Your Ref: OWQC21427
Our Ref: EP/1/19/HH
Please ask for:
Mr Z Denton

12th February 2019

Proposed single-storey rear extension, two-storey side extension, porch to front
including demolition of existing outbuilding
1 Lashmar Road East Preston

Proposed West (Front) Elevation 1:100

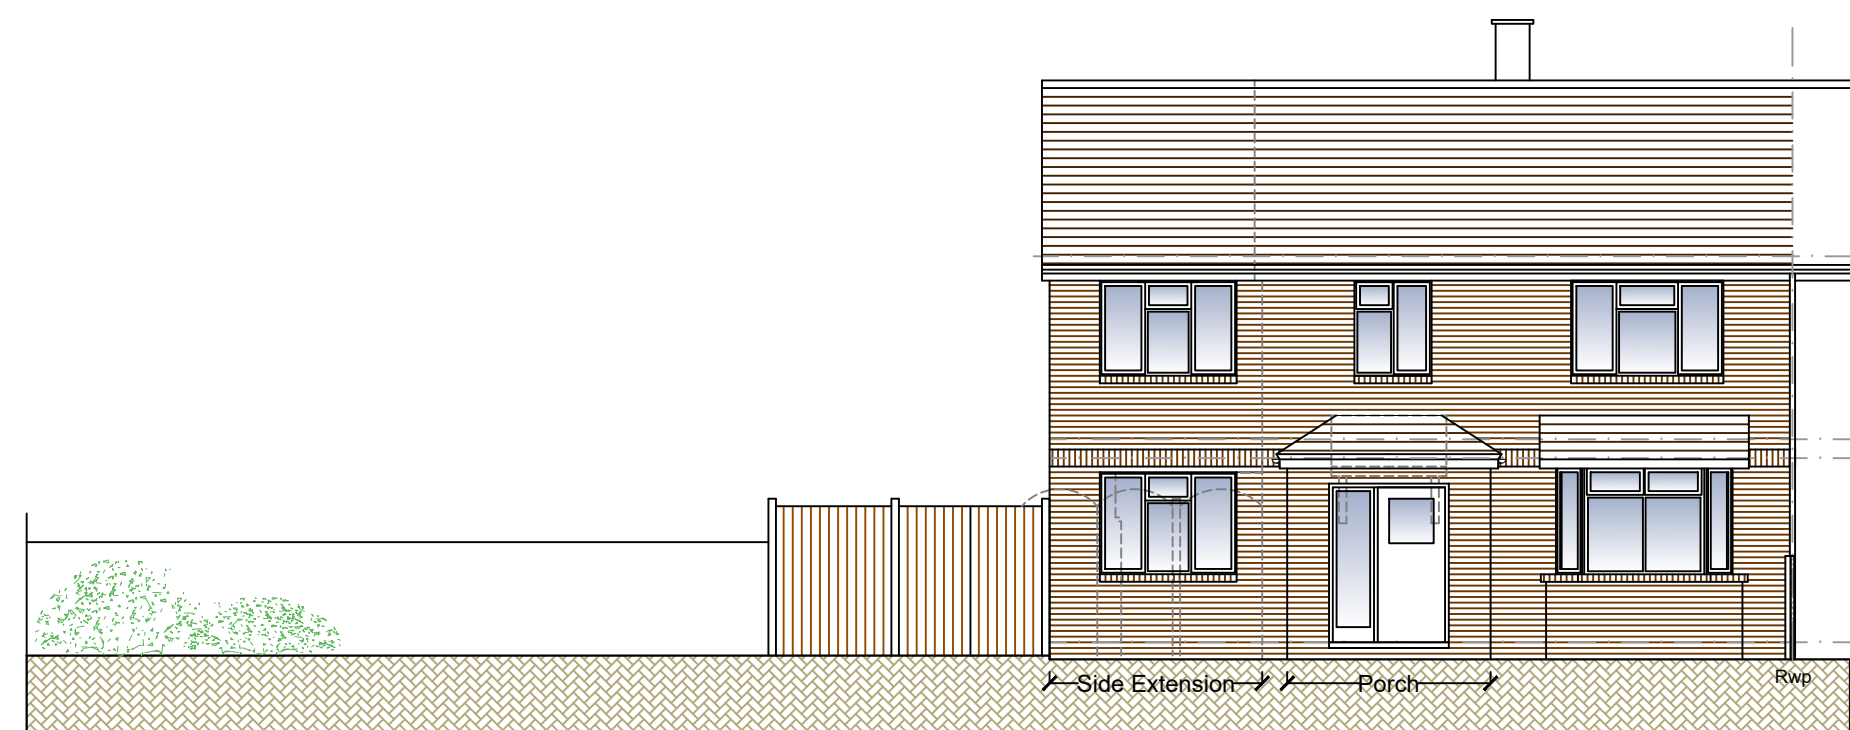
The committee agreed unanimously not to raise any objections to this Application. However, it did feel the design might benefit from a matching roof over the ground-floor window of the proposed extension. I have contacted the agent about this.
